CITY OF ALBUQUERQUE

June 13, 2022

RE: 543 Old Coors Dr. SW
Grading and Drainage Plans
Engineer's Stamp Date: 06/11/22
Hydrology File: K11D027

Based upon the information provided in your submittal received 06/01/2022, the Grading & Drainage Plans **are not** approved for Building Permit, SO-19 Permit and Grading Permit. The following comments need to be addressed for approval of the above referenced project:

**GRADING PLAN
DETAIL**

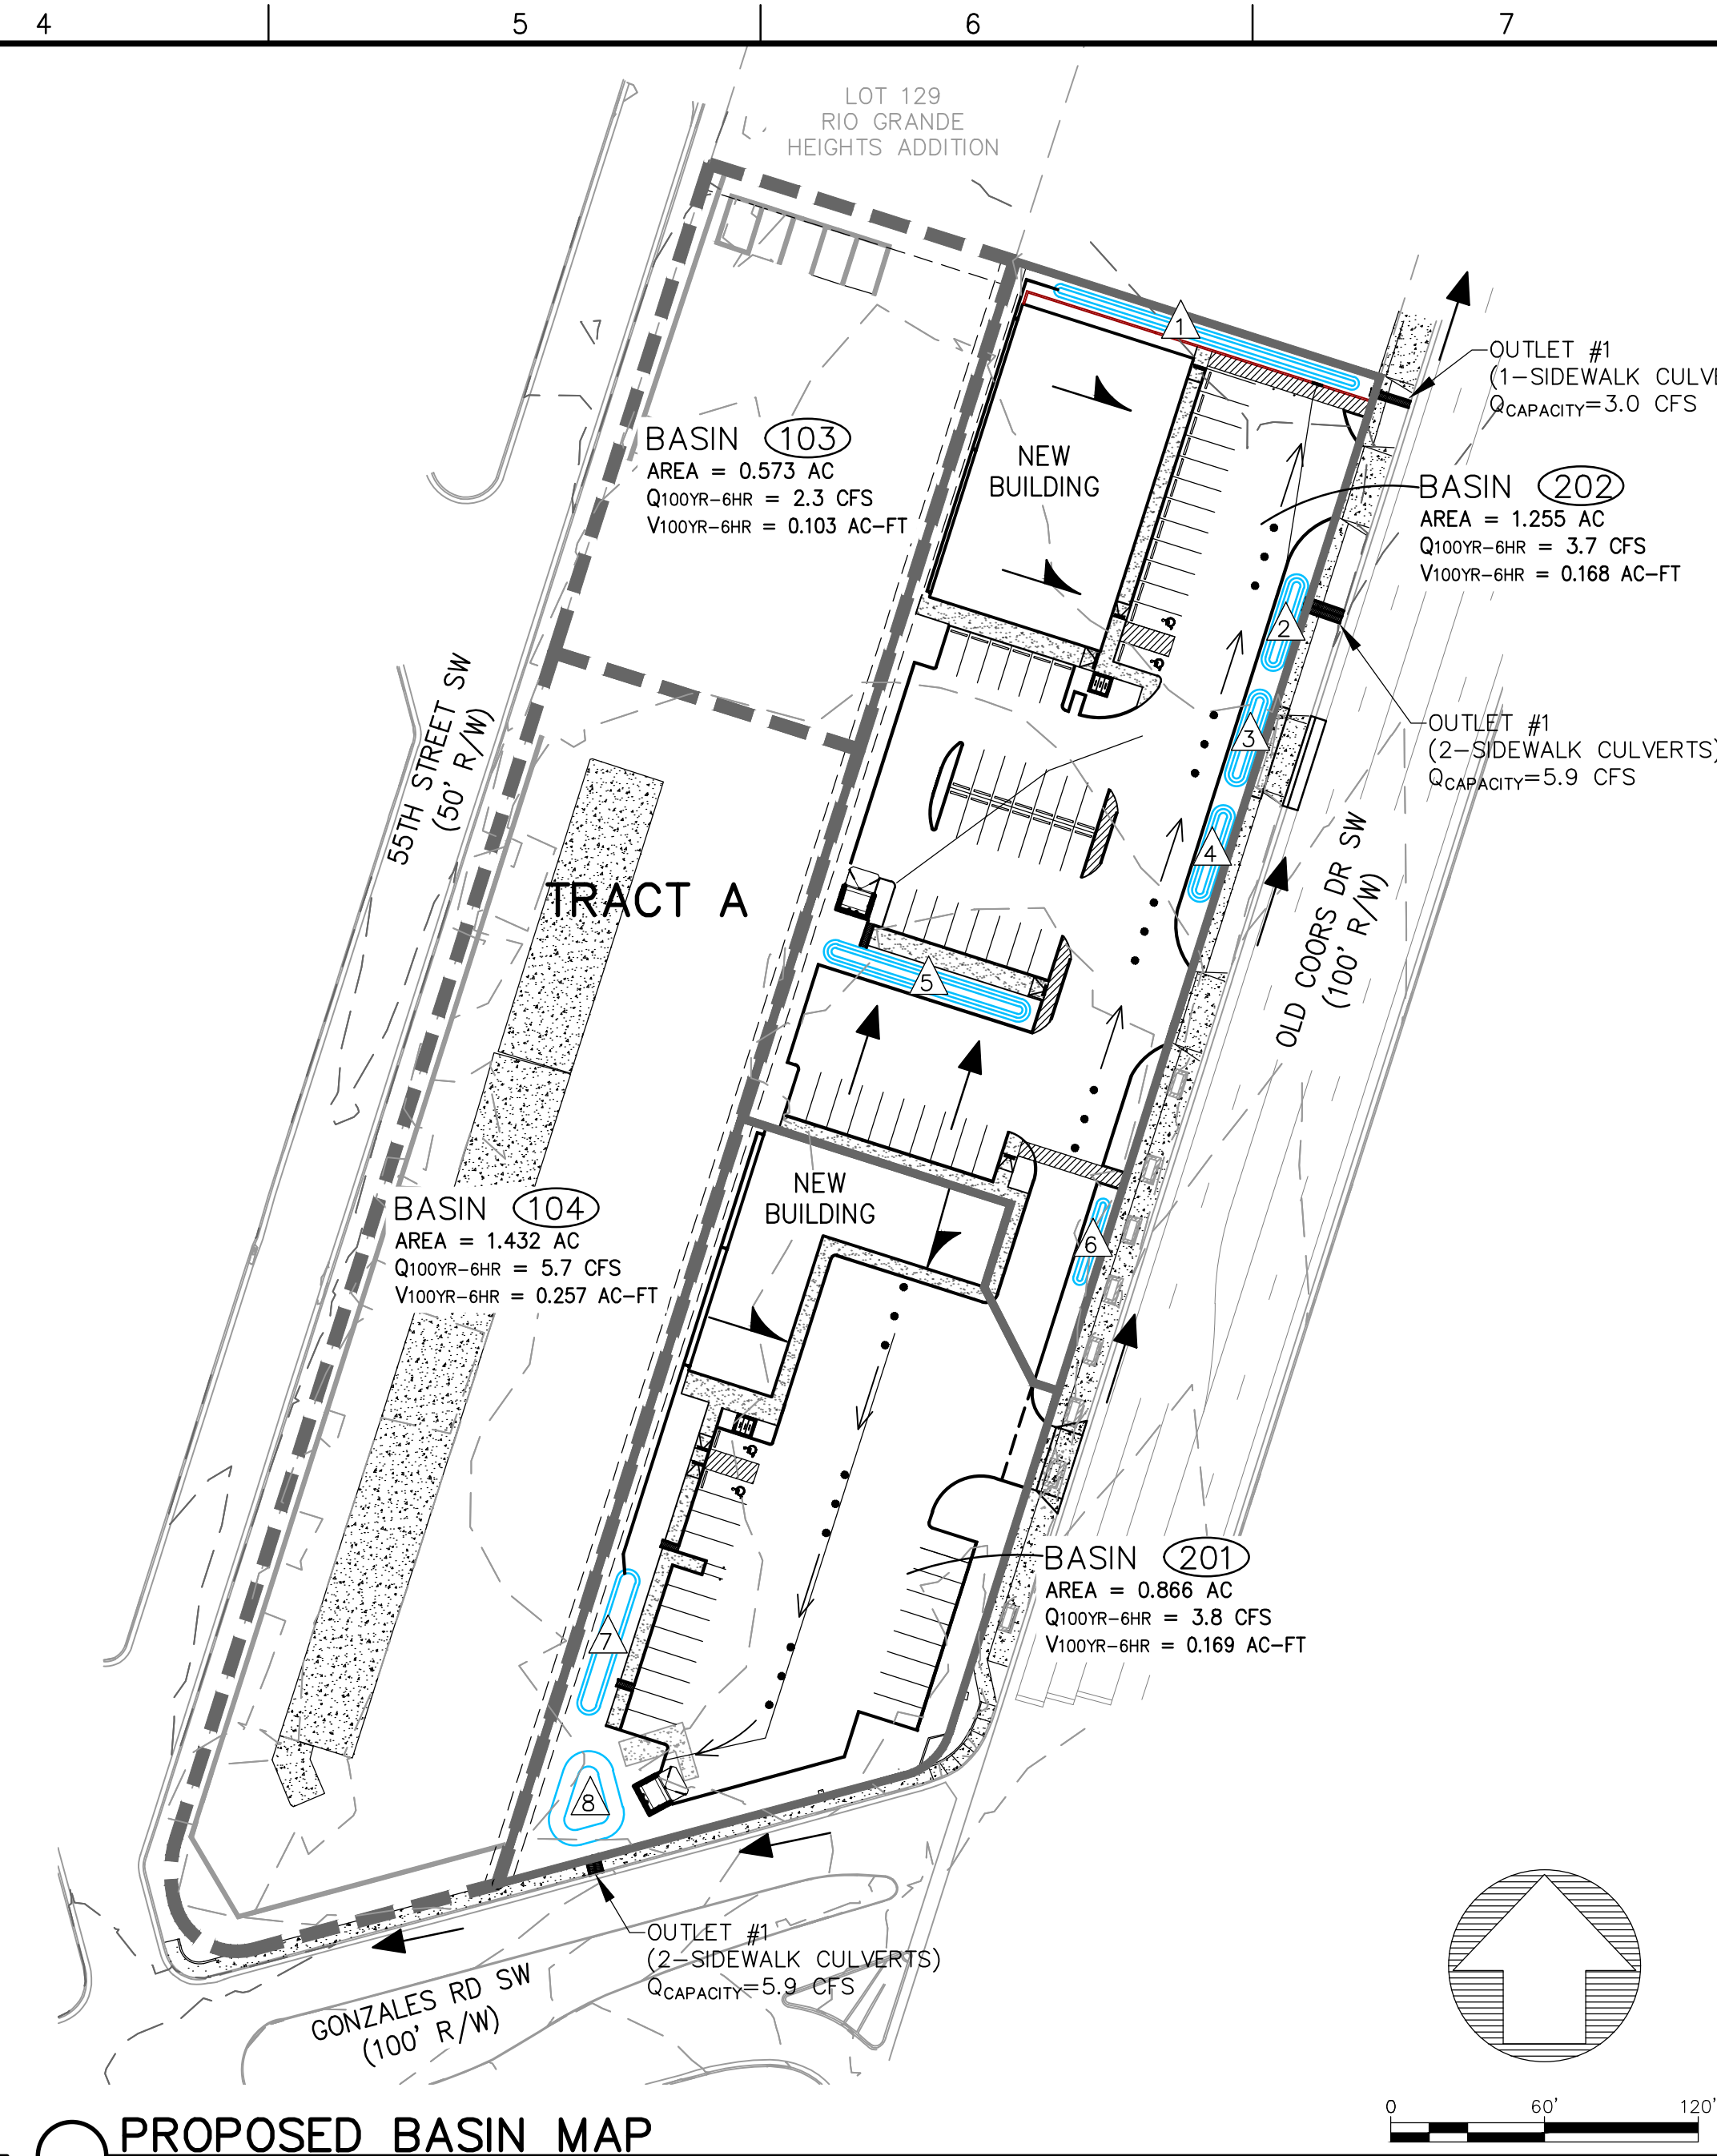
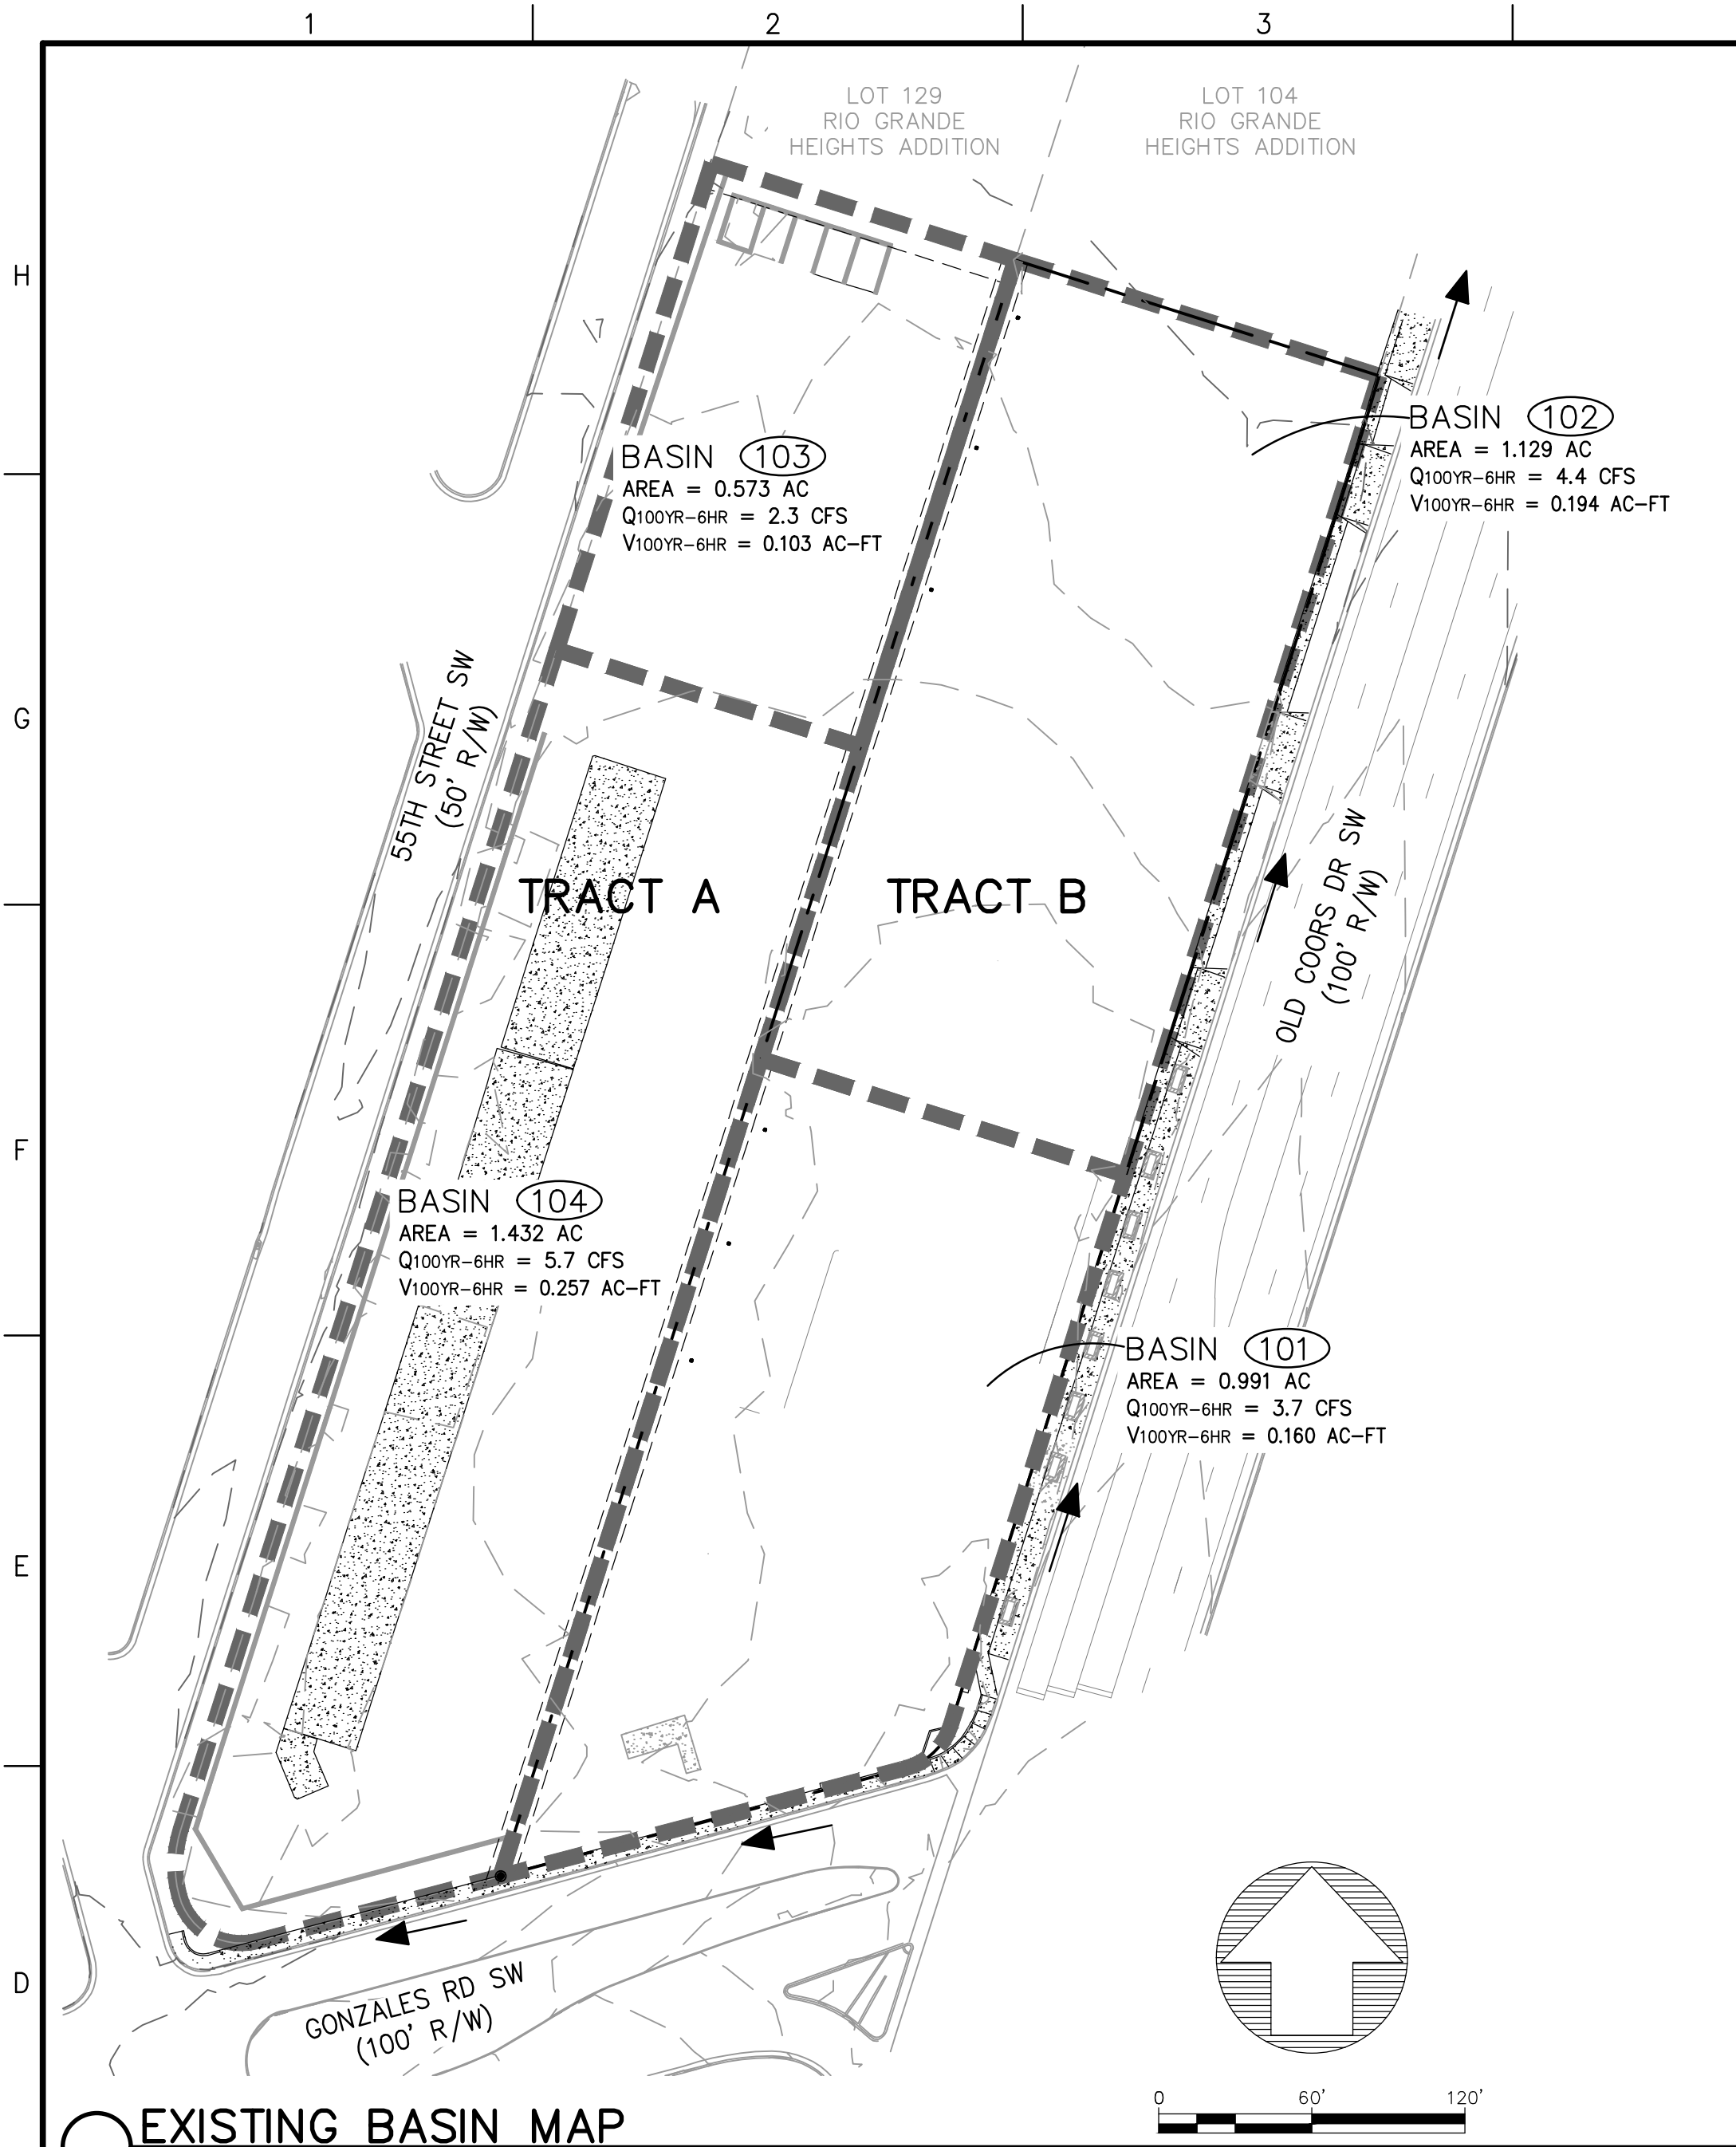
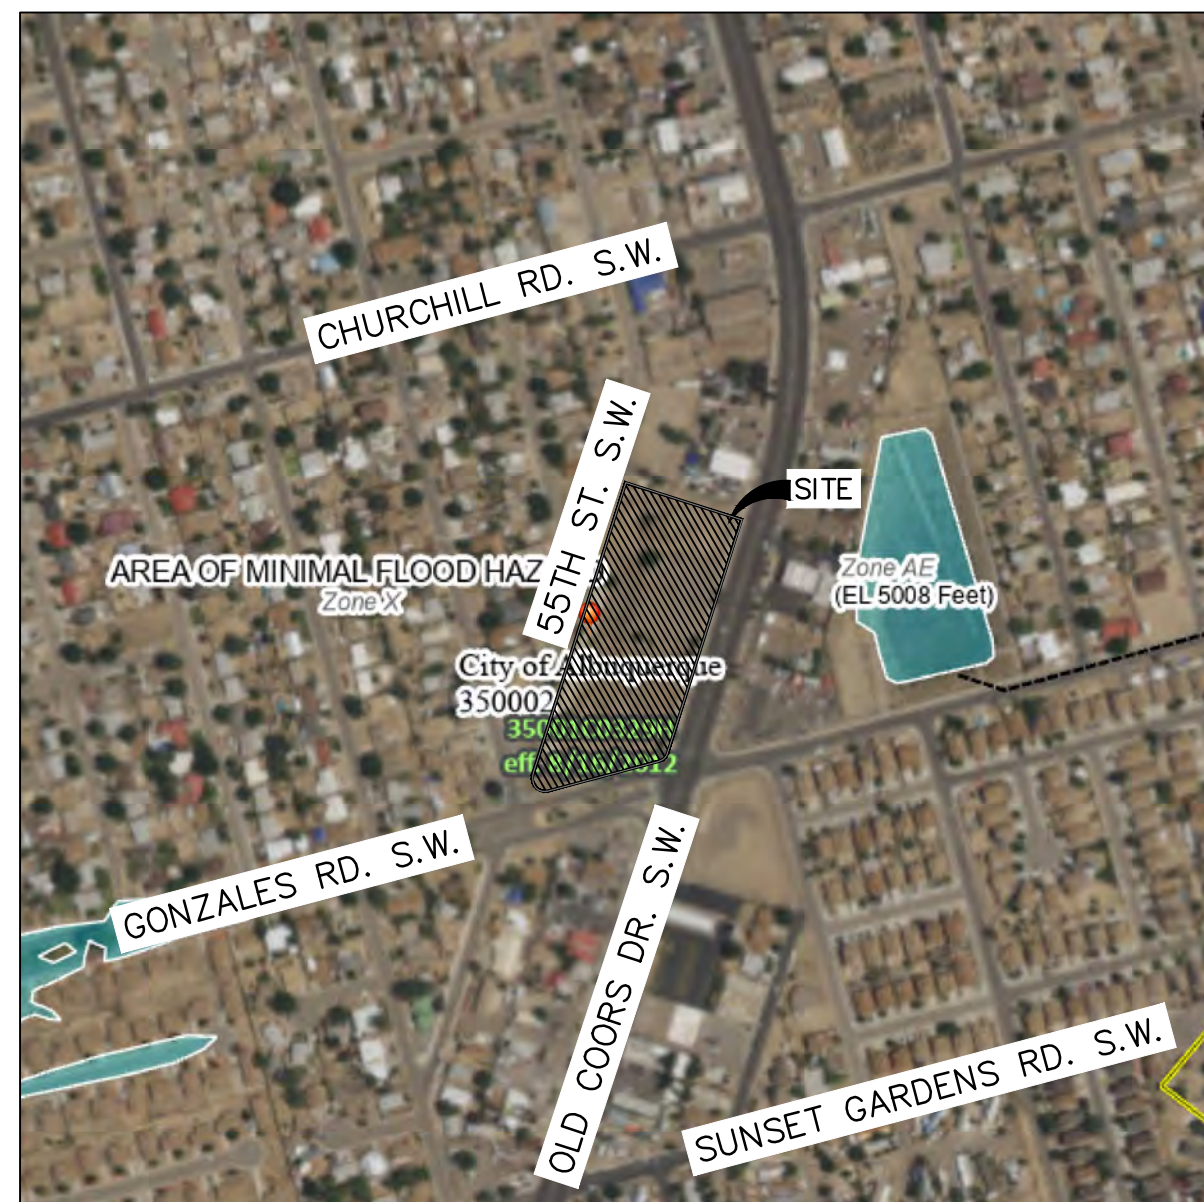
13. Why is this portion of the parking over the property line and into Tract A? Also, where is the edge of the asphalt from the parking to the header wall?

14. How is this detention /stormwater quality pond being discharged? There needs to be some sort of spillway / outfall for it. Please revised.

15. How is this detention /stormwater quality pond being discharged? There needs to be some sort of spillway / outfall for it. Please revised.

16. Again, I am not quite sure where the edge of asphalt is on this project. Also, what is this piece of concrete for? Is it proposed or existing? All the lines are the same line weights so it is hard to tell what is being proposed and what is existing.
